Please upload as substitute plans for FP/218/19/PL

I am the officer on the application FP/218/19/PL at Abergail, Clyde Road.

PROPOSED GROUND FLOOR PLAN

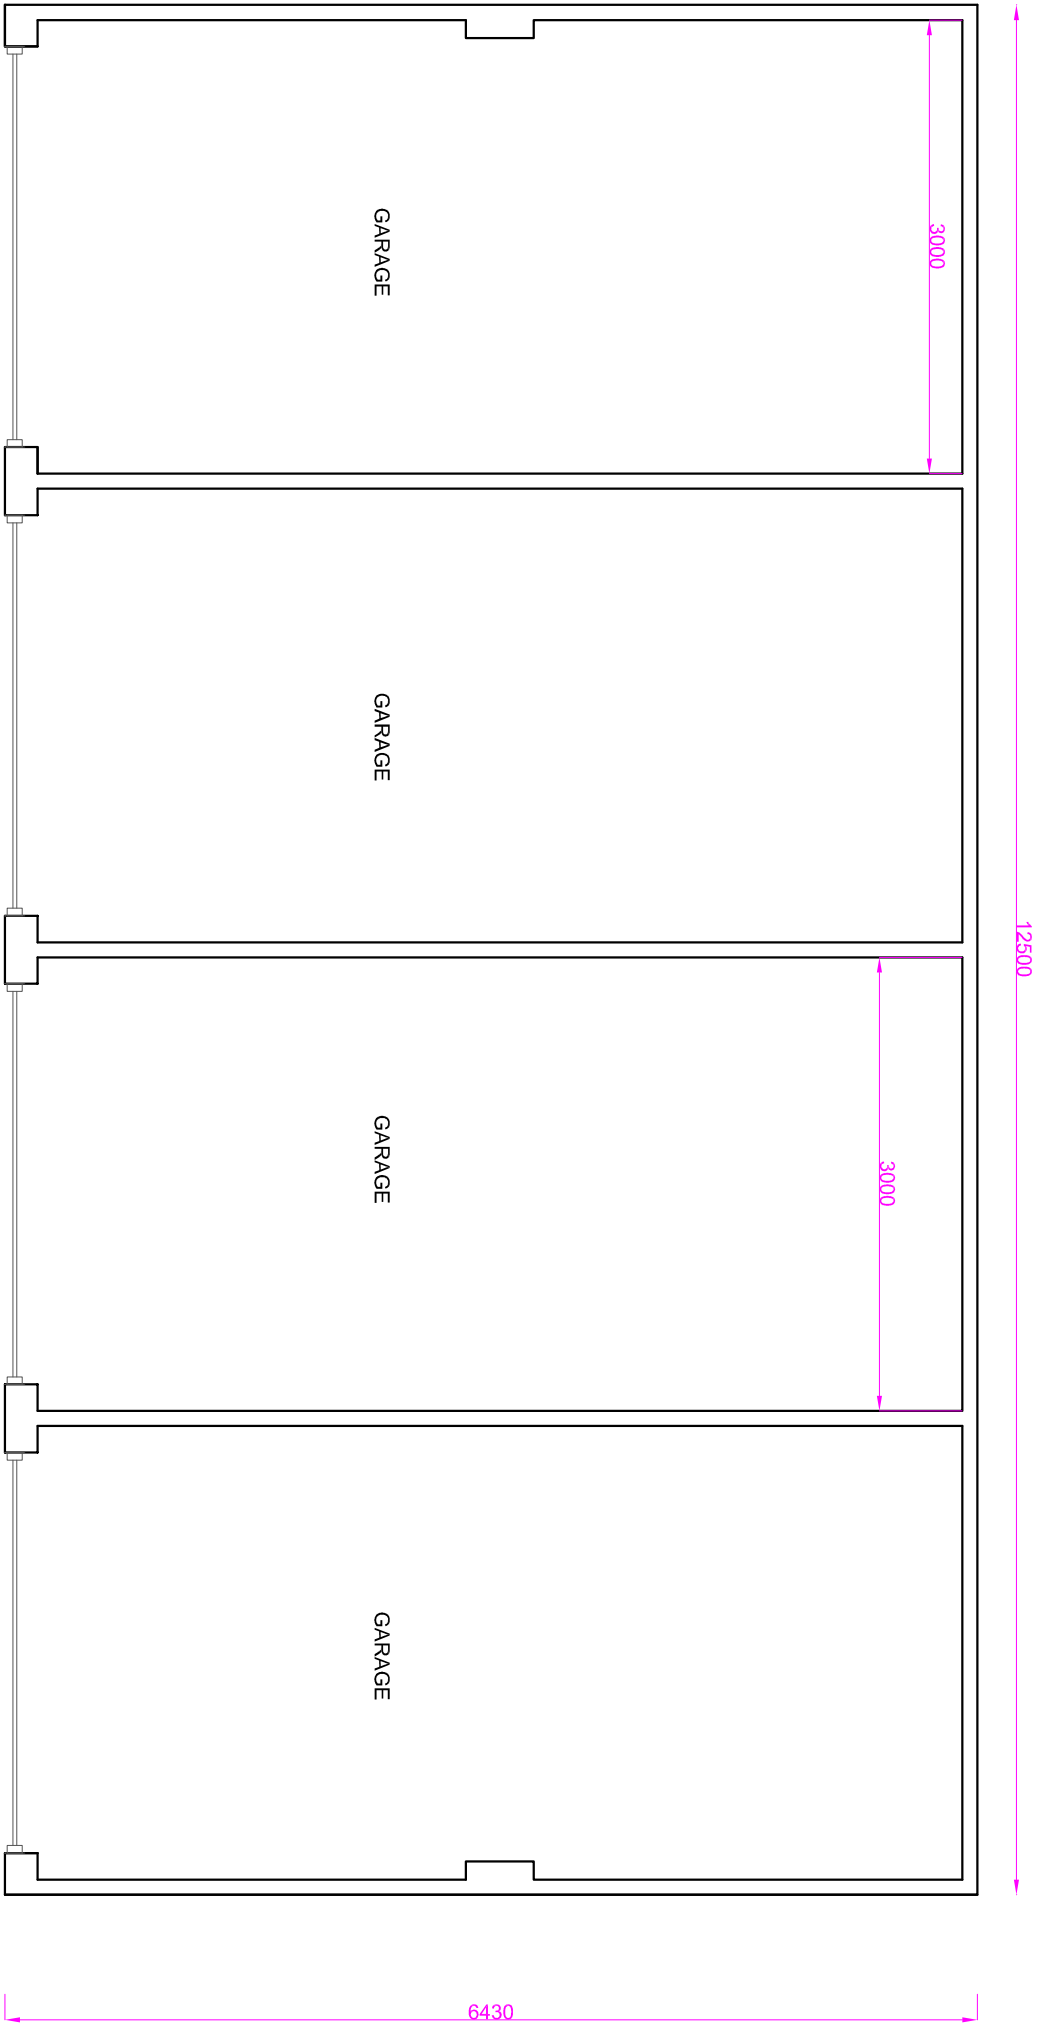
I have received a consultation response from West Sussex in which they require a modification to the plan. I attach this above.

Please can the amendment be submitted and then I will re-consult.

I have consulted with my client and following your email we have adjusted the size of the garage to give the 3.0 metre internal width that WSCC sought. The depth of the garages remain unchanged
